Recommendation Report for Planning Permission

REF NO: BR/14/26/PL

LOCATION: Bottom Flat
9 Stocker Road
Bognor Regis
PO21 2QH

PROPOSAL: Proposed annexe to rear garden which is ancillary to the main dwelling. This application is in CIL Zone 4 and may be CIL liable.

ELEVATIONS AS EXISTING 1:100 @ A4.

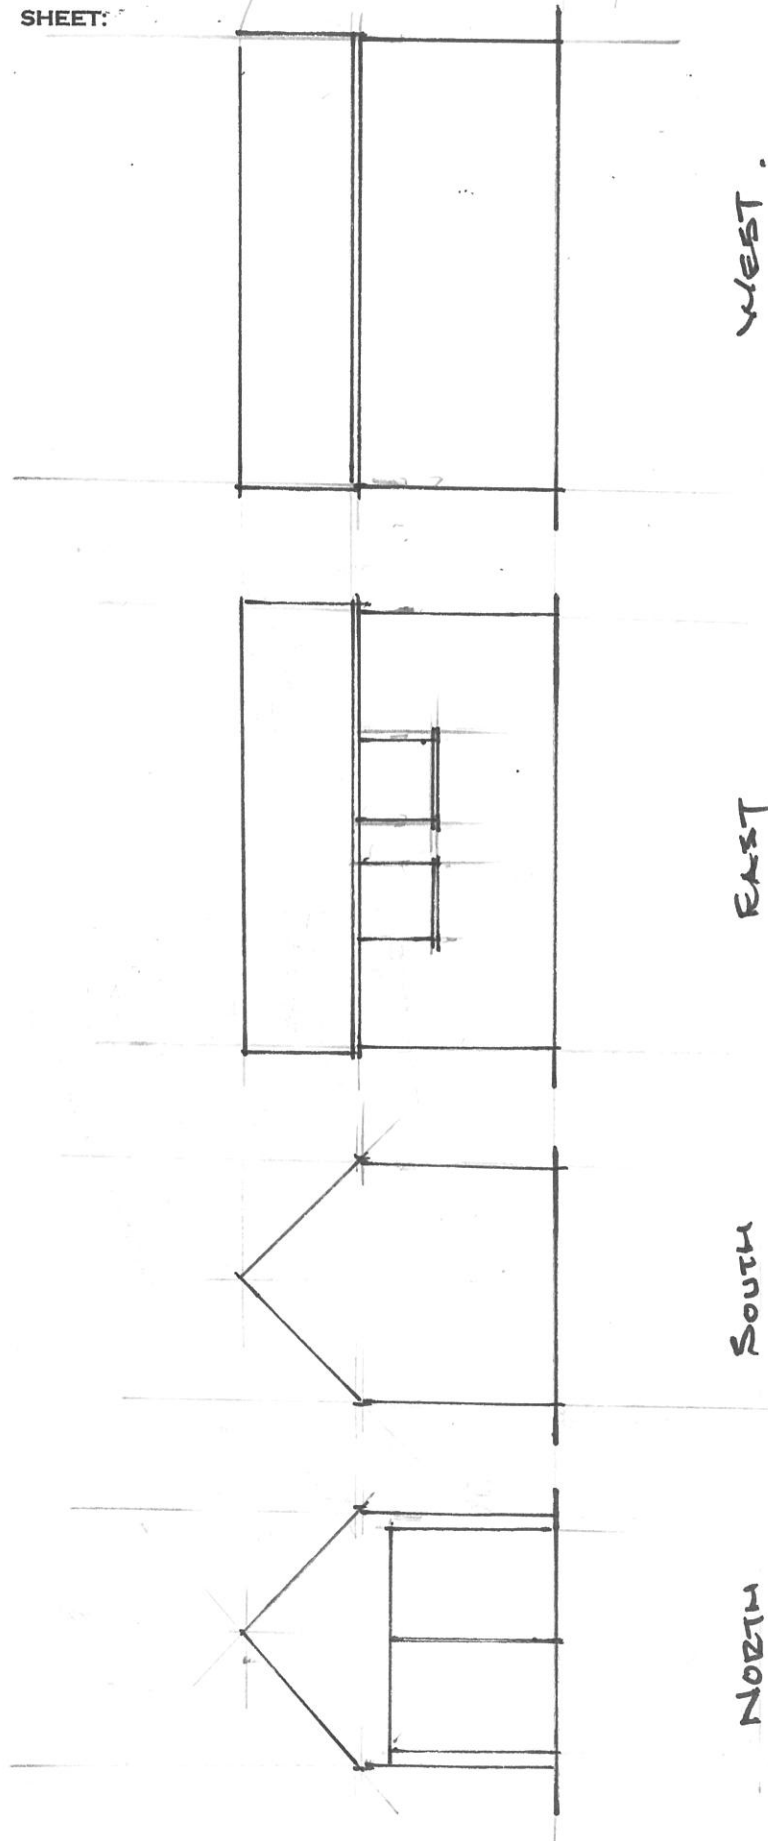
The annexe has a pitched roof and would be 4m high. Existing elevations show the existing outbuilding having a height of 4m, however, following a site visit to the property, the actual height of the existing building is thought to be lower than shown. The ridge height of the annexe is likely to be higher than the ridge height of the garage. A height of 4m would not be excessive for an outbuilding with a dual pitched roof, given that Class E of the General Permitted Development Order permits outbuildings in the curtilage of dwellings to be a maximum of 4m high. As the host property is a flat this type of permitted development does not exist.
